Landscaping Plan

Owners: Joseph Prue & Stephanie McDiarmid

Landscape Plan Drawings_V1.pdf Markup Summary

Landscaping Plan

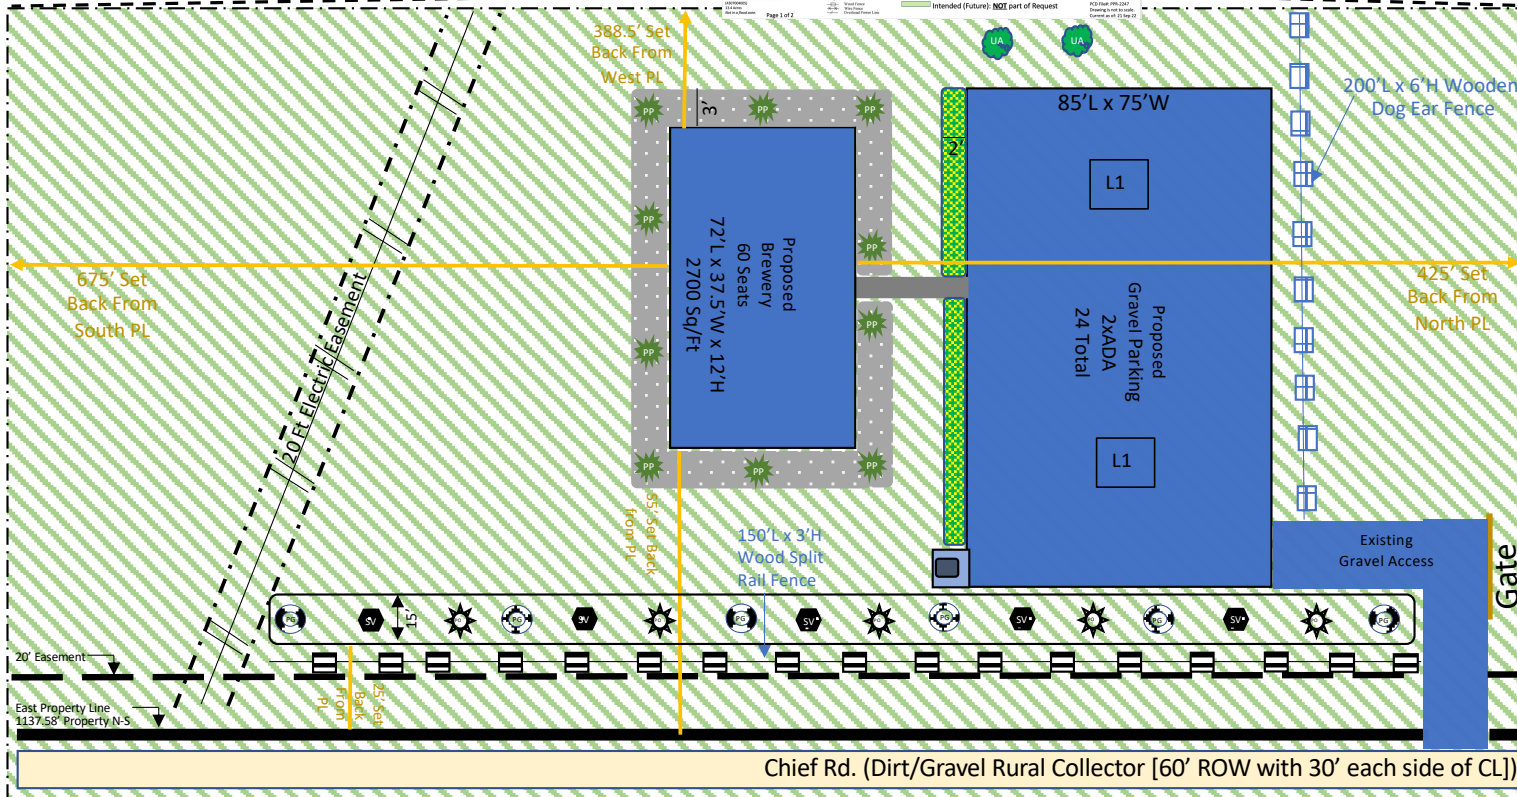
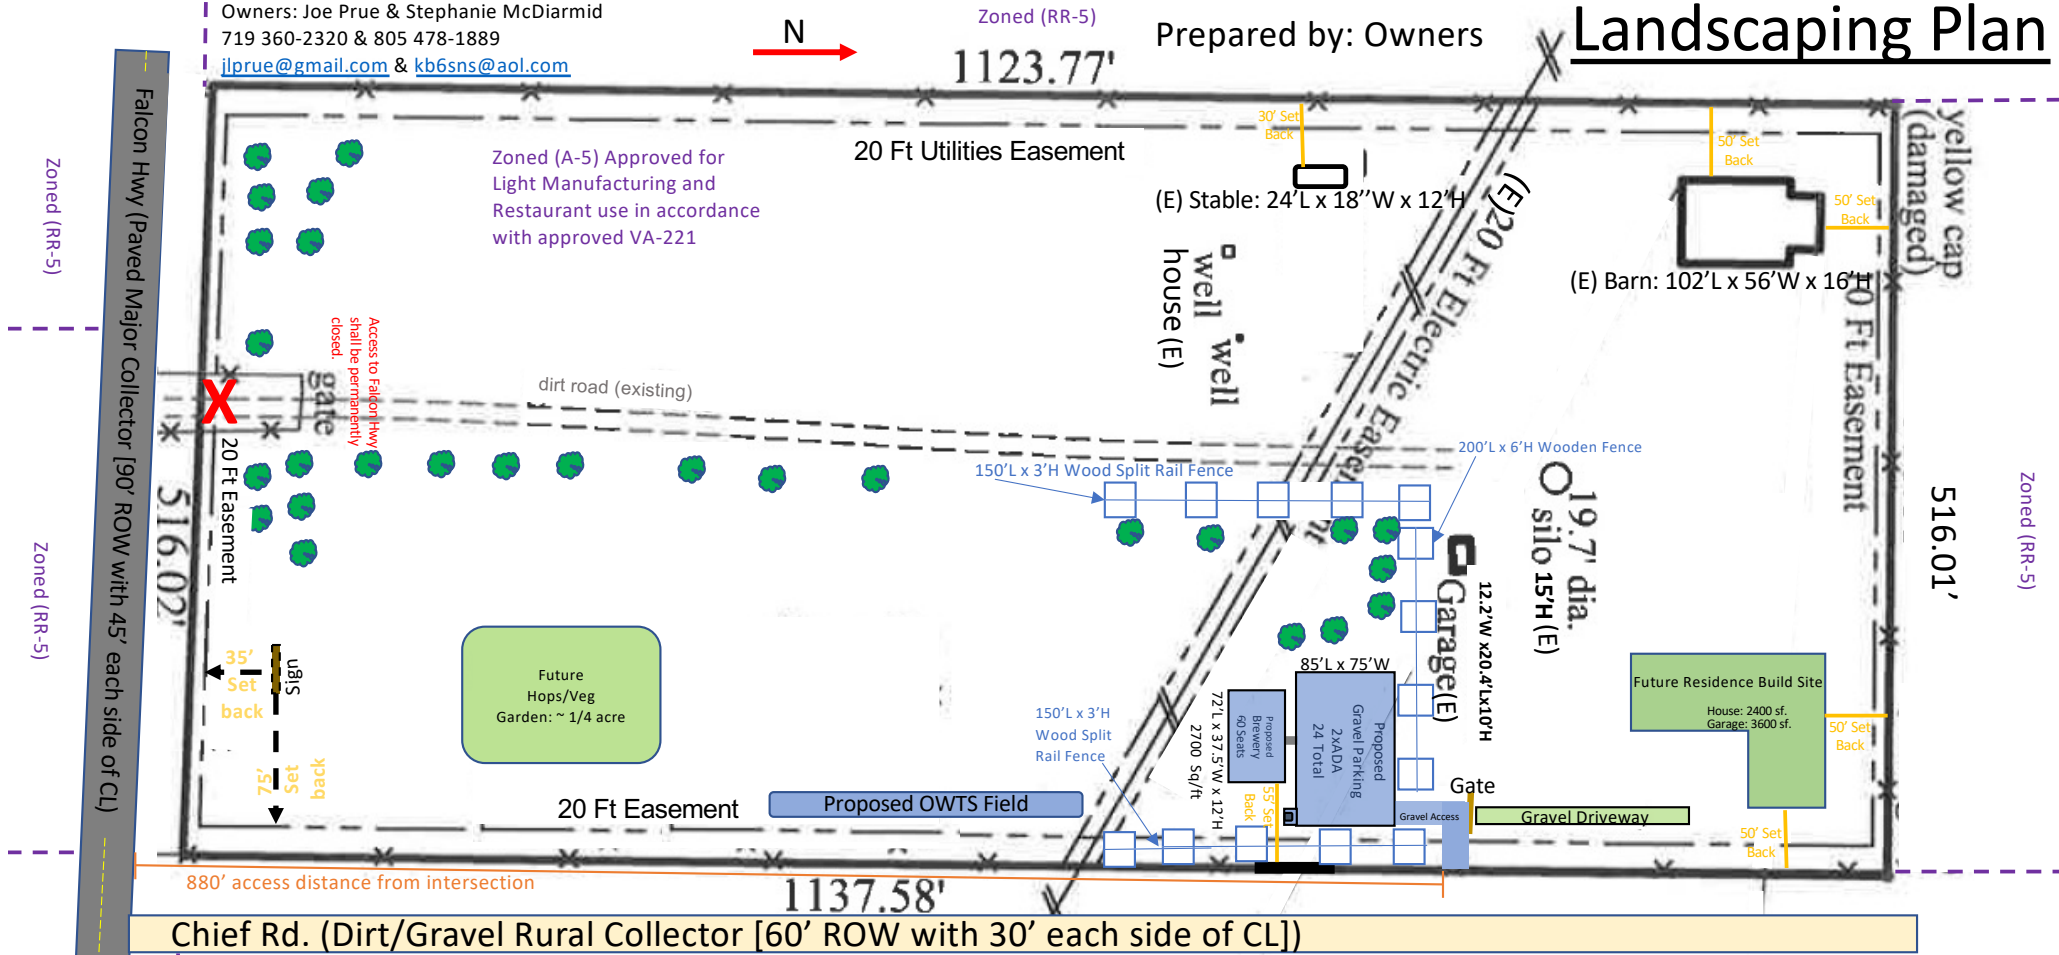
Label landscape buffer and setbacks on entire site

Label all existing structures (E)

Provide a detail of the fence

Provide landscape deviation request or clarify in LOI & plan why the value is "0"
